8<sup>th</sup> February 2021

**Reference: M25 Junction 28 Improvements representation**

Status	A4	Project Title	M25 junction 28 improvement scheme
Description	<b>BIODIVERSITY SITES AND FEATURE PLANS</b> <b>REGULATION 5(2)(I)</b> <b>KEY PLAN</b>		
Drawing Number	TR010029/APP/2.9	Rev.	2
HE PIN:	HE551519	Scale:	1:12500
Original Size:	A1

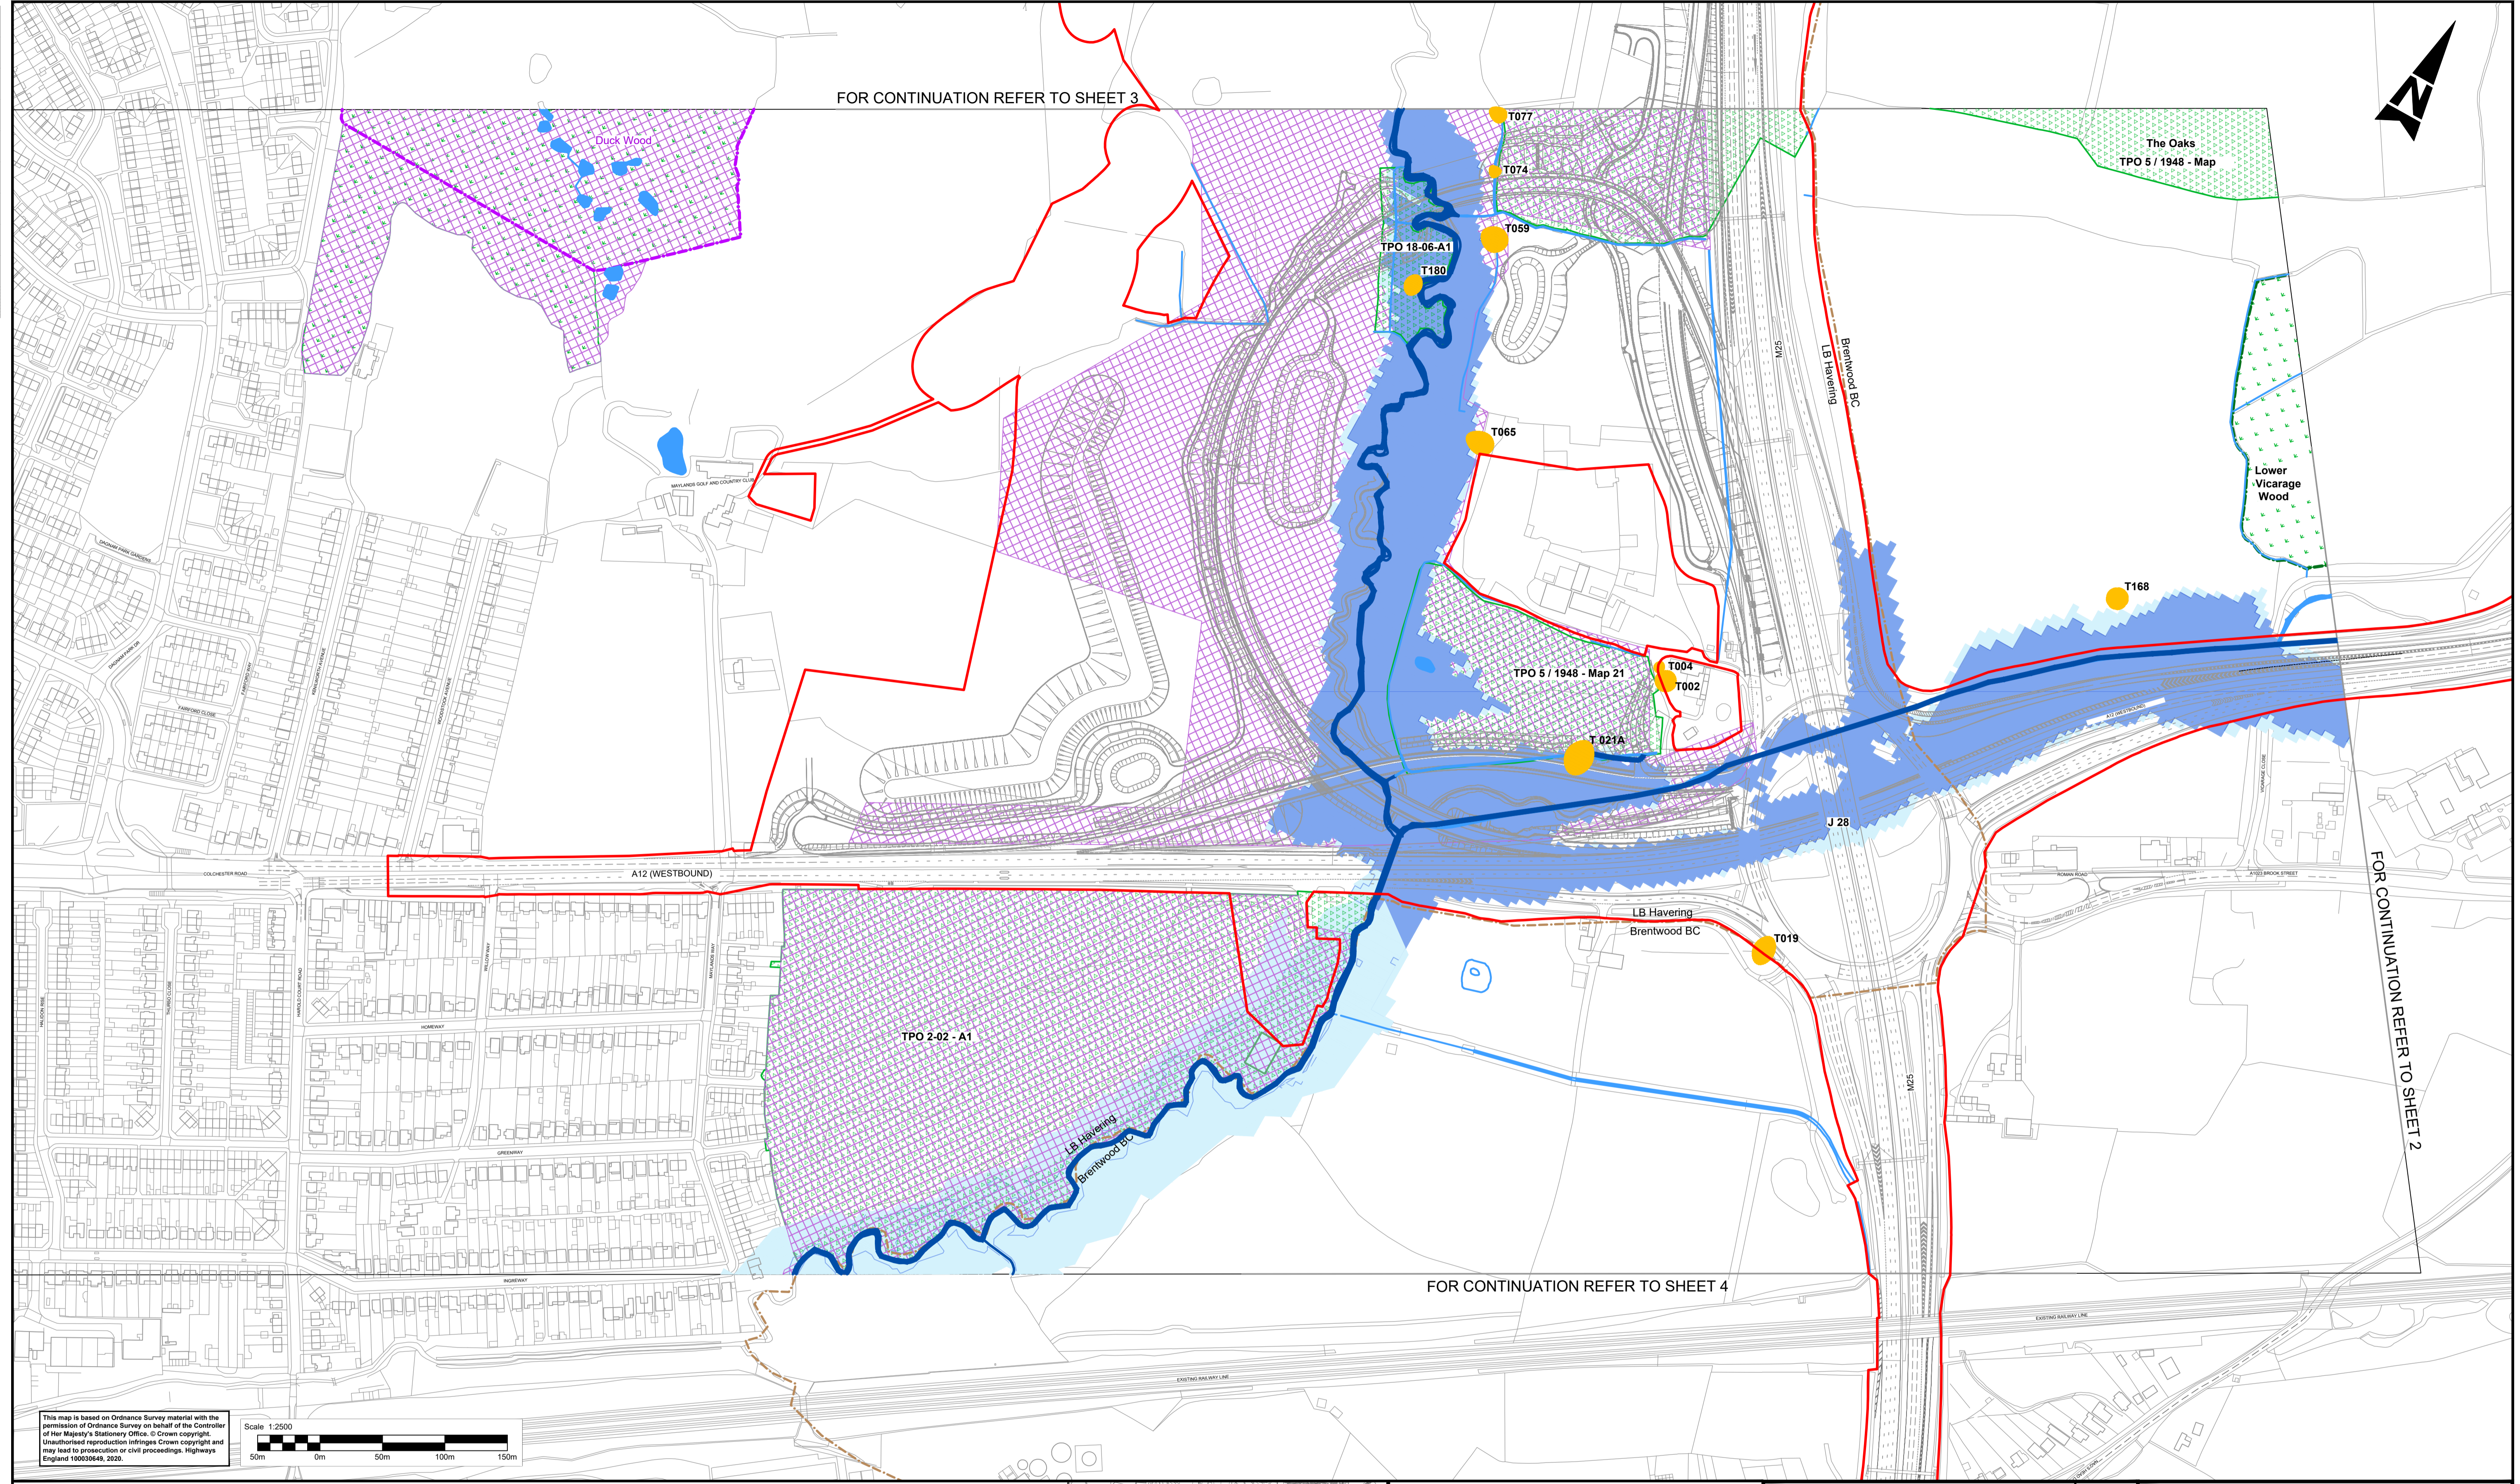
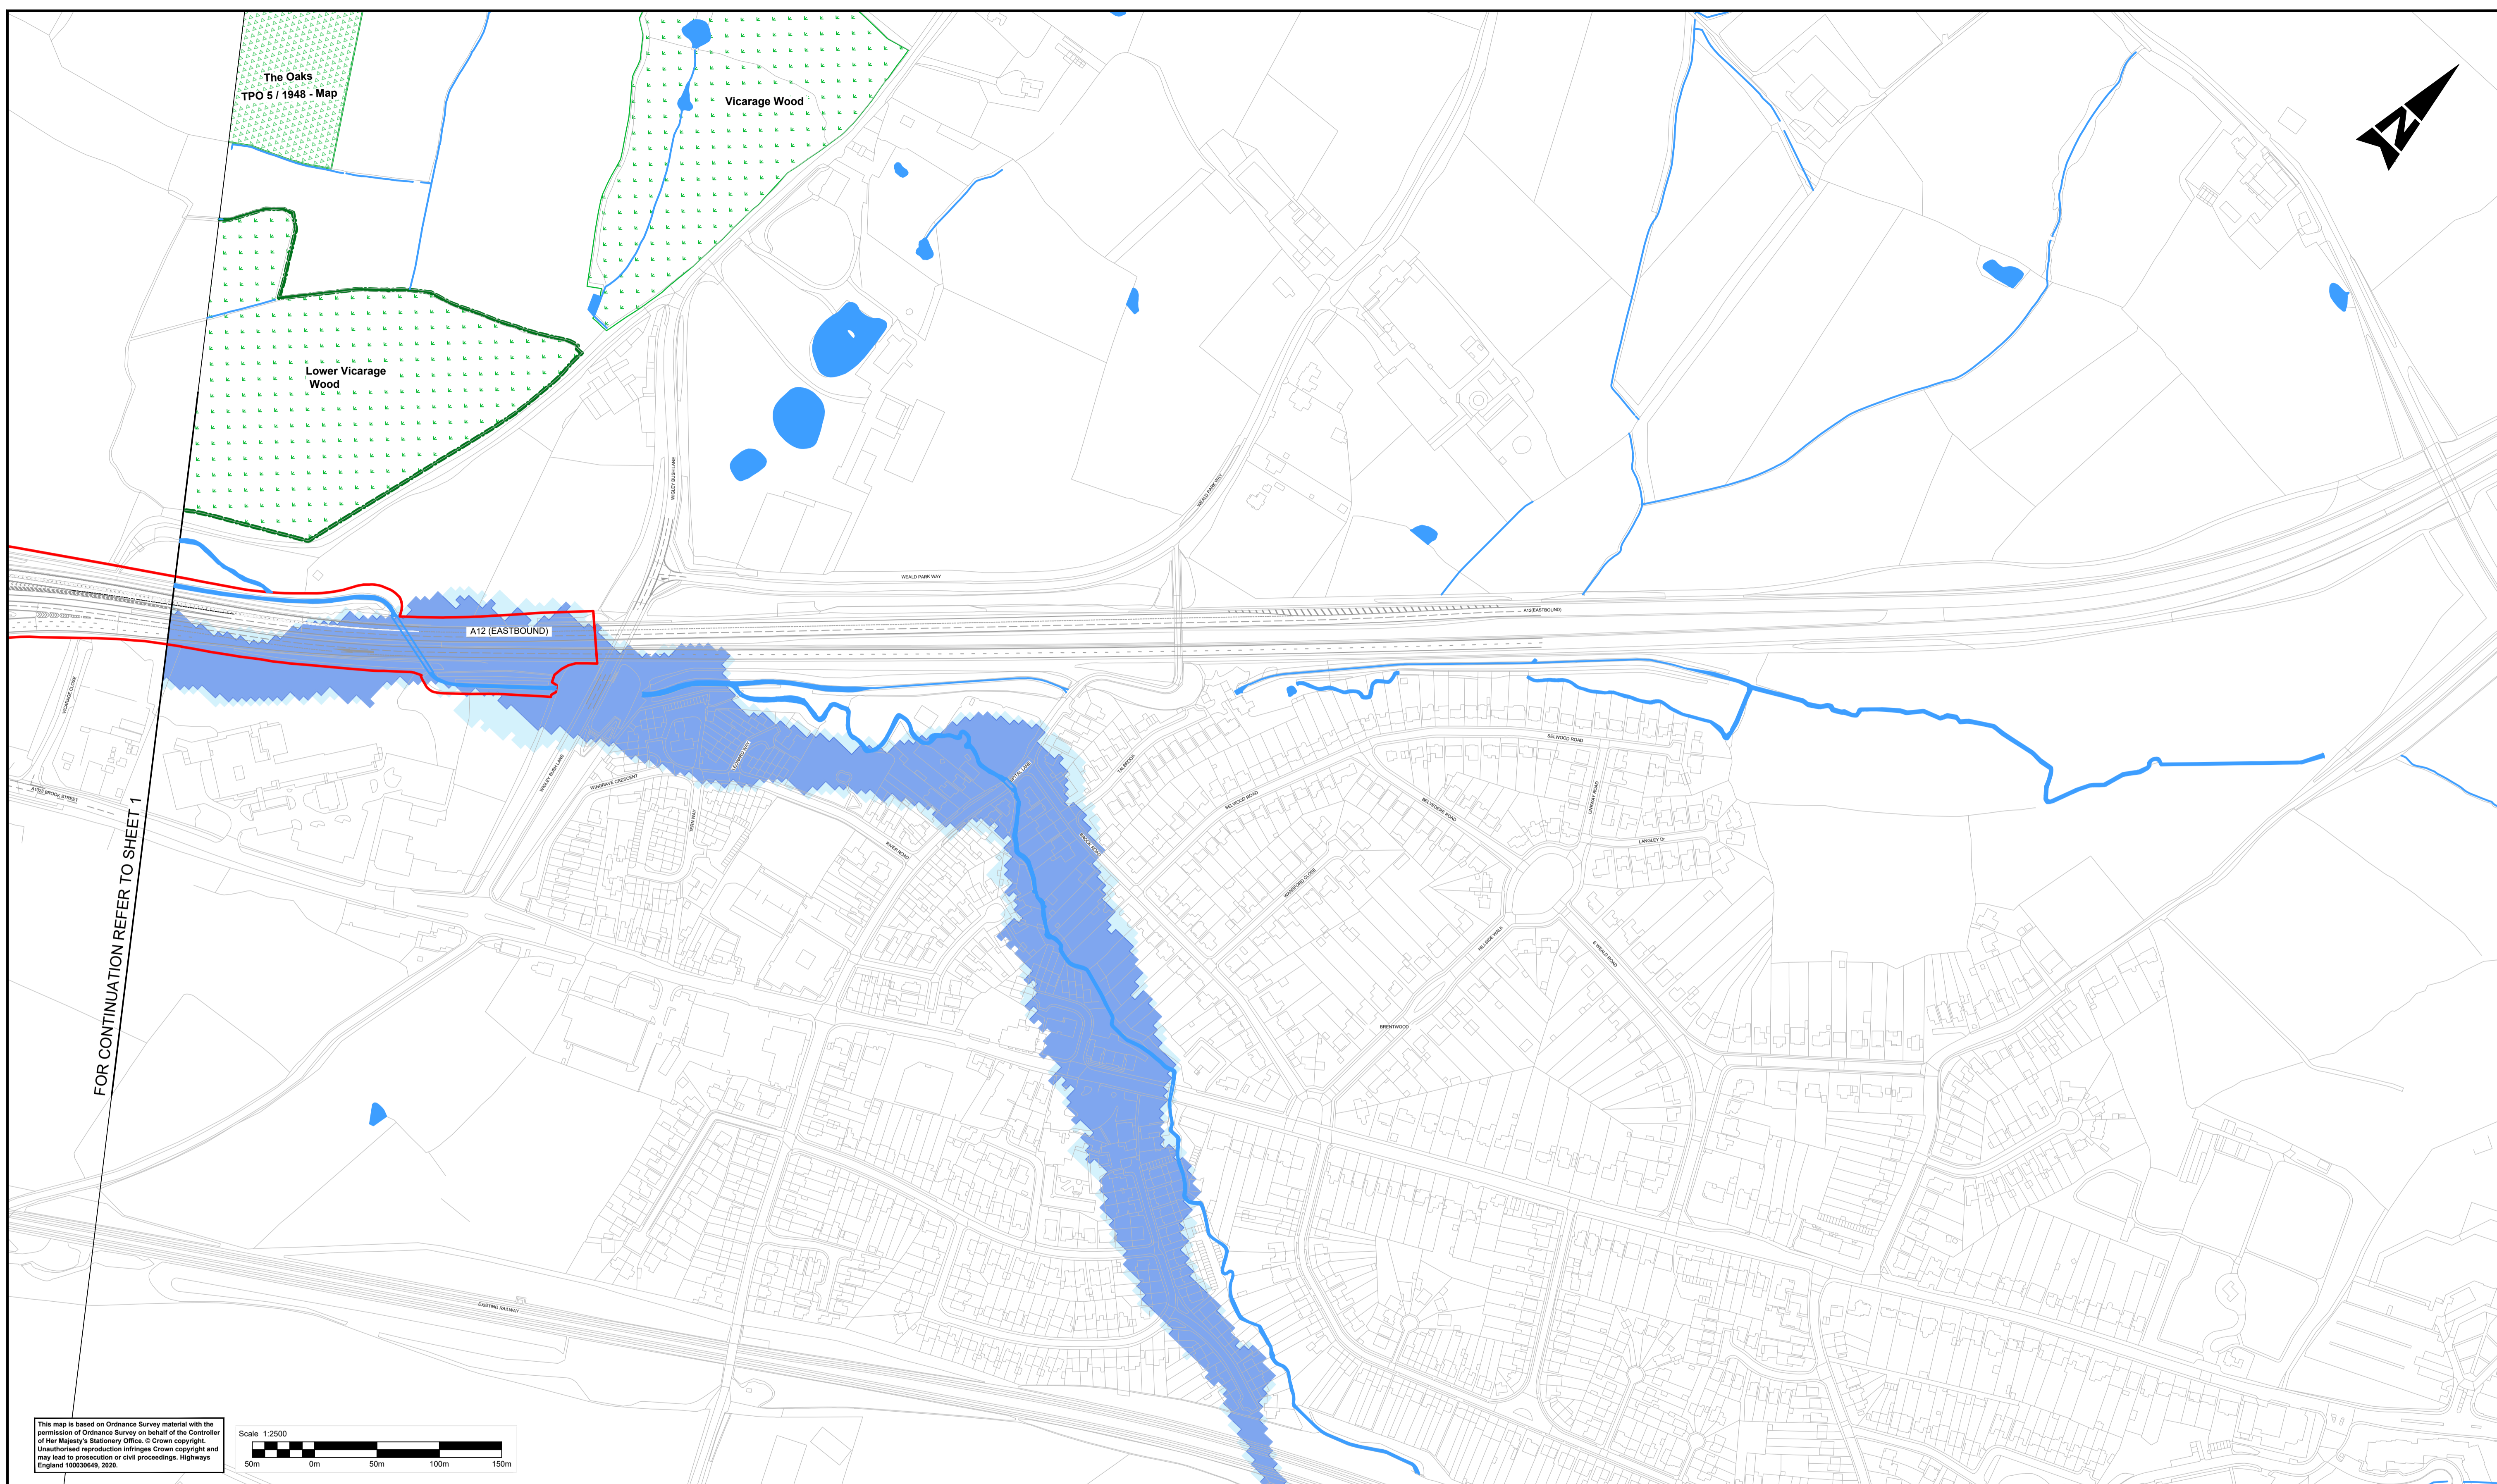
The proposed improvements to the M25 Junction 28 will result in potential impact to several veteran trees identified within the Arboricultural Impact Assessment [Reference: APP-063] either through direct loss of specimens in order to facilitate construction (T021A and T074) or through damage to the root systems via encroachment of root protection areas (RPA).

It is essential that no trees displaying veteran characteristics are lost or damaged as part of the project. Any loss of veteran trees would be highly deleterious to the wider environment of veteran trees within close proximity, which may harbour rare and important species.

In summary, the Woodland Trust requests that all trees displaying veteran characteristics are retained and adequately protected with a Root Protection Area in line with Natural England's Standing Advice.
